**WSCC CONSULTATION RESPONSE:  
County Planning – Minerals & Waste Planning Authority (MWPA)**

<b>TO:</b>	Arun District Council Case Officer: Jessica Riches		
<b>DATE:</b>	22 October 2024		
<b>LOCATION:</b>	Ford Airfield, Ford		
<b>SUBJECT:</b>	F/16/24/RES: Approval of reserved matters following outline permission F/4/20/OUT for phase reserved matters 4 (south), for the erection of 357 No. residential dwellings plus associated roads, infrastructure, parking, landscaping, open space & play areas and associated works.		
<b>RECOMMENDATION:</b>	<input type="checkbox"/> Advice	<input checked="" type="checkbox"/> Objection	
	<input type="checkbox"/> Modification	<input type="checkbox"/> No Objection	
	<input checked="" type="checkbox"/> More Information	<input type="checkbox"/> Refusal

Figure 4-1: Commercial & Industrial Operations

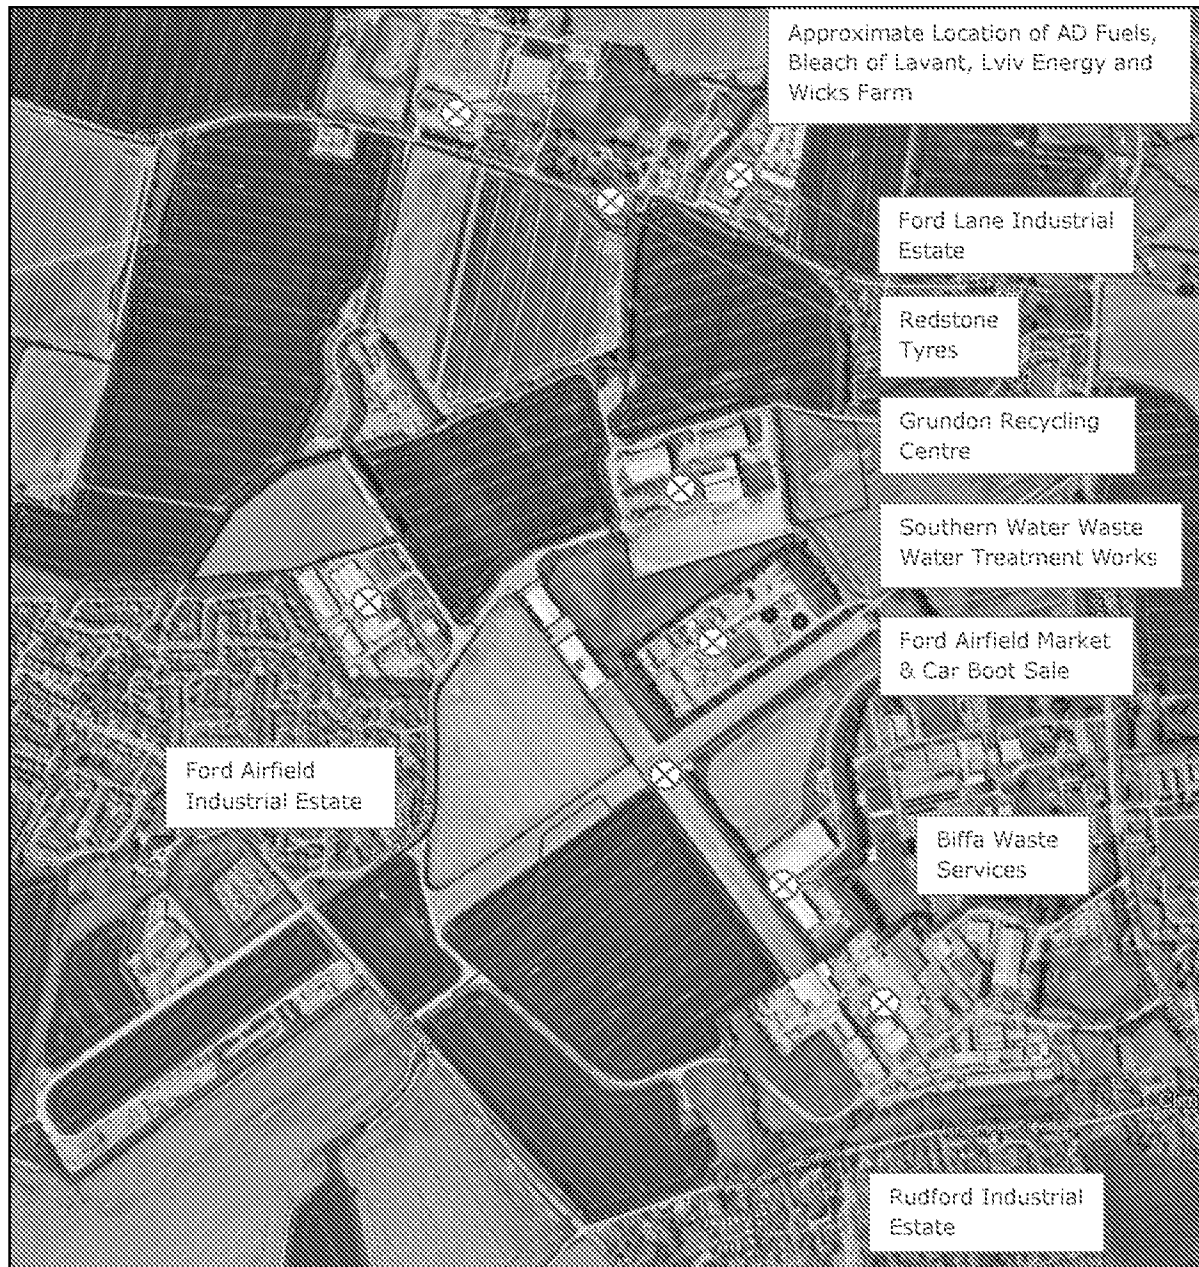
It is unclear the extent to which the noise assessment has considered a likely worst-case scenario for noise generated by the MRF (or whether this is based on monitored levels over a limited survey period)? It is crucial that any assessment of noise arising from the MRF is representative of full extent of permitted activities.

Table 4-1 and Paragraph 4.32 of the noise assessment suggest an increase in noise levels of 6dB above background, and thus predicts an adverse impact for residential dwellings closest to the MRF at night. This is a substantial increase over that originally predicted at the outline stage, and thus of concern.
